RE: PD-16-00001

Project name: Carrier Heights Planned Unit Development and,

LP-1700004MDJ Plat:

Project name: MDJ Contractors Long Plat

SHEET CONTENTS
SITE PLAN

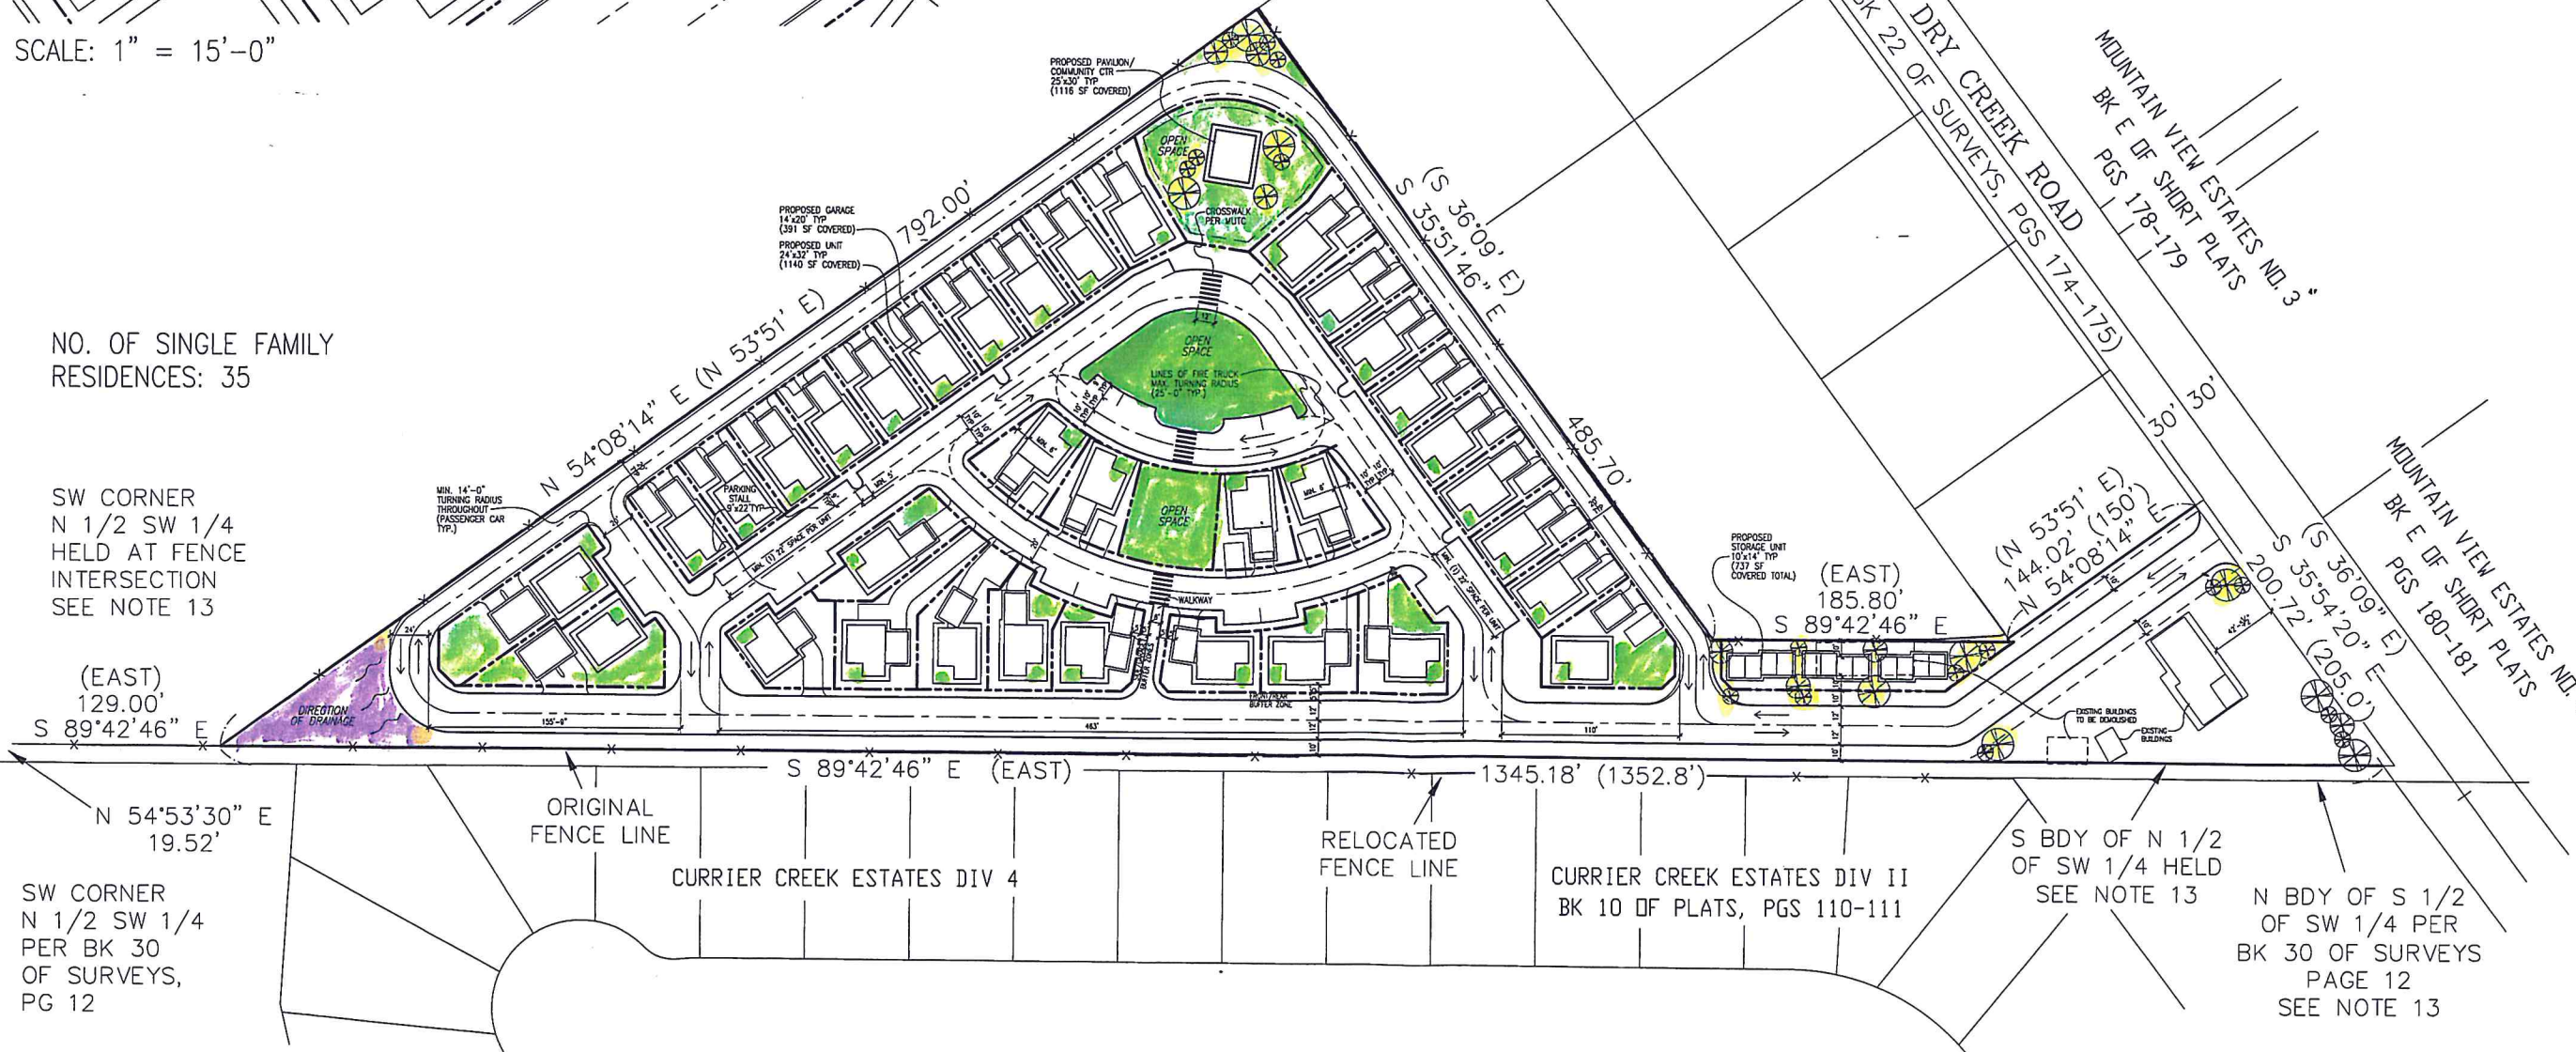
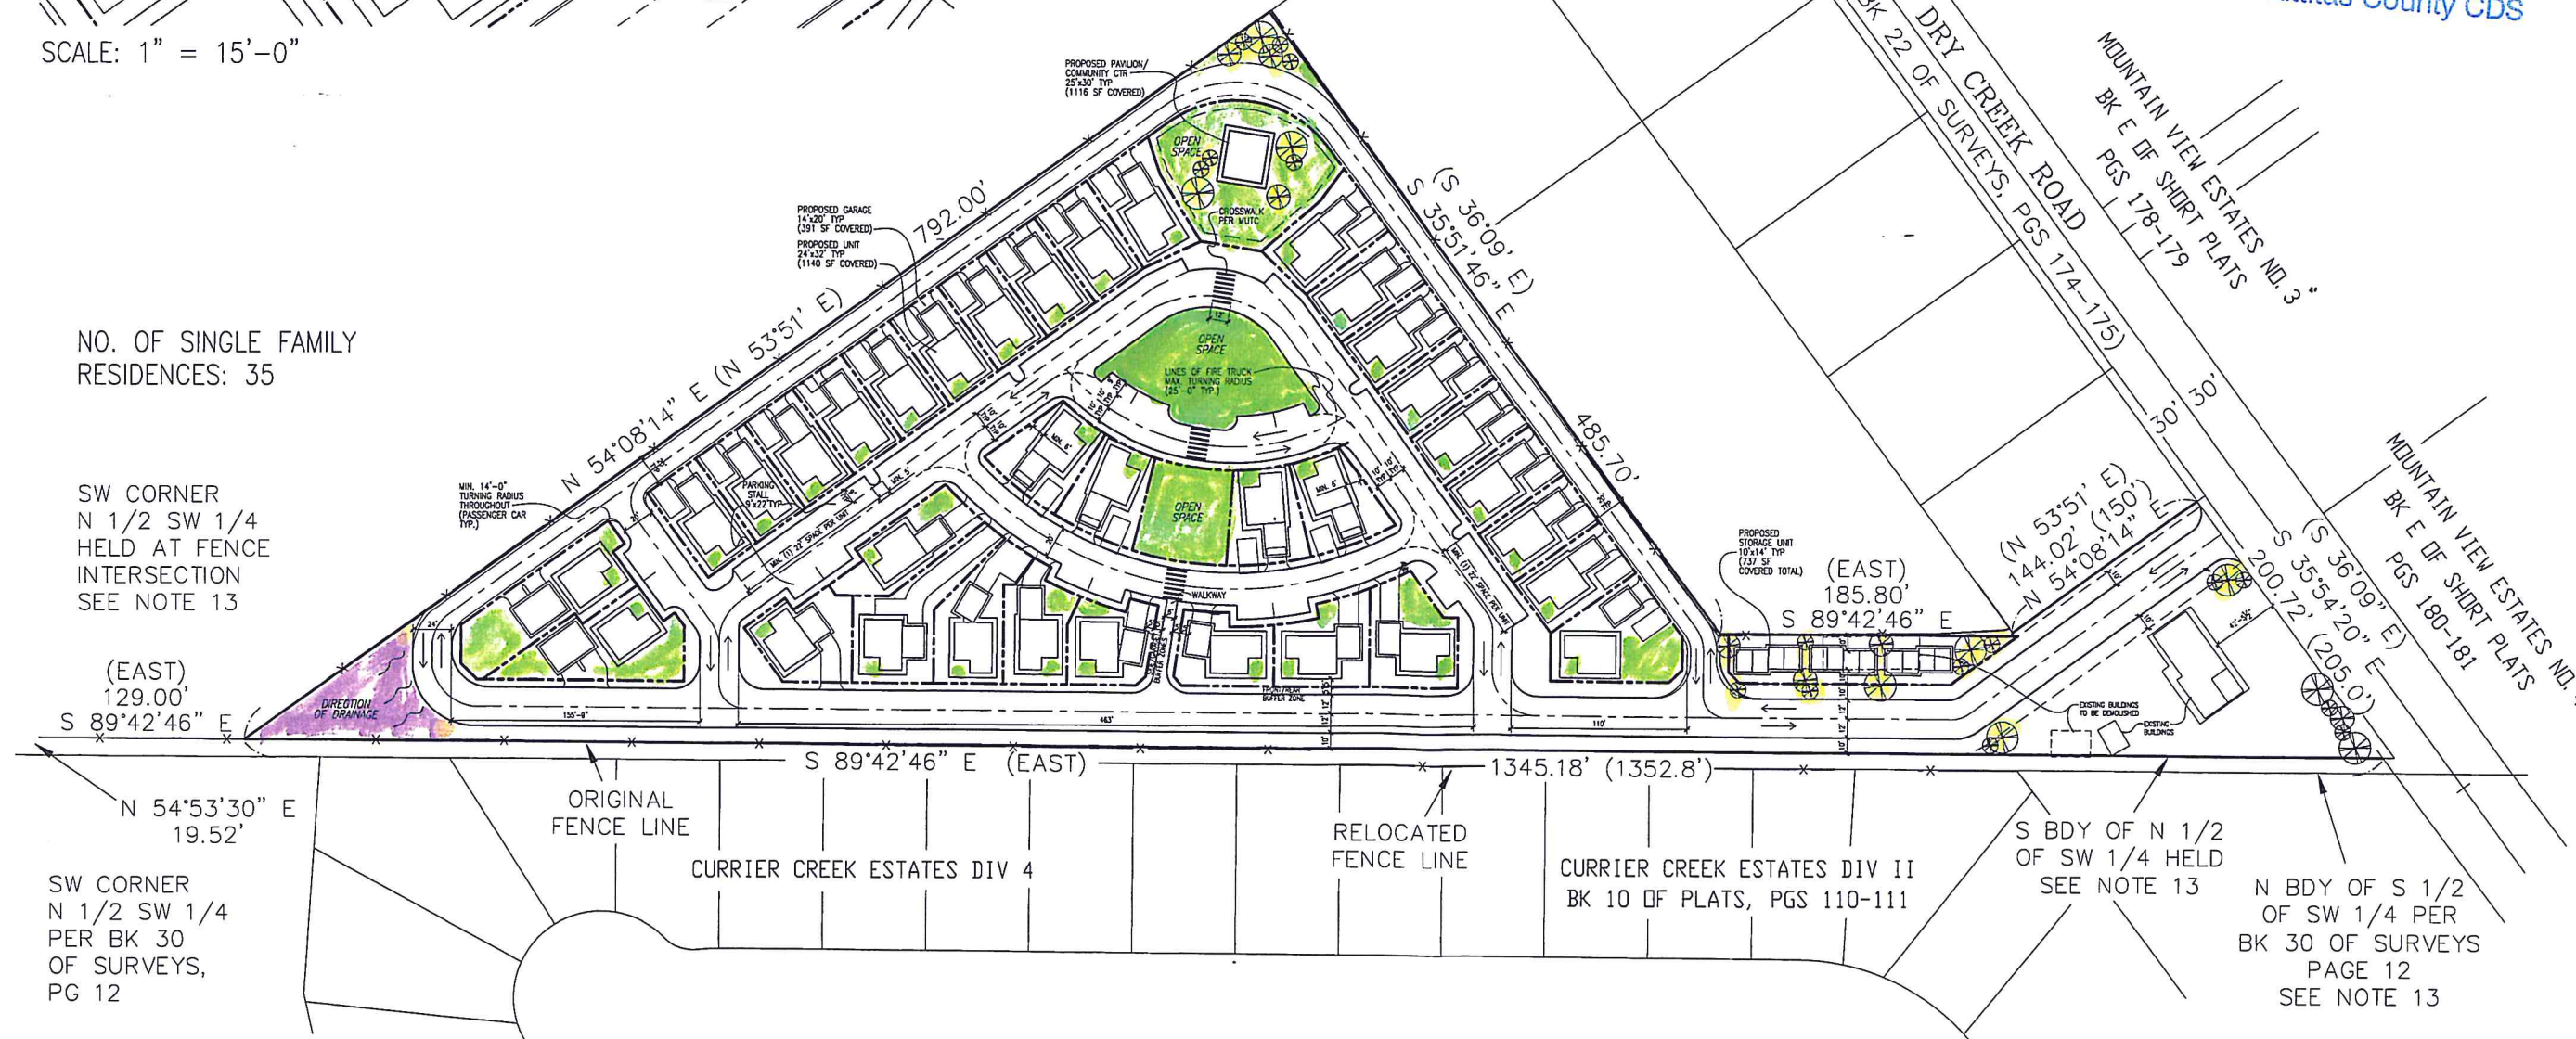
We are concerned about points of entry and exit for the proposed Planned Unit Development and Long Plat identified above. The material provided on your web site does not make this clear.
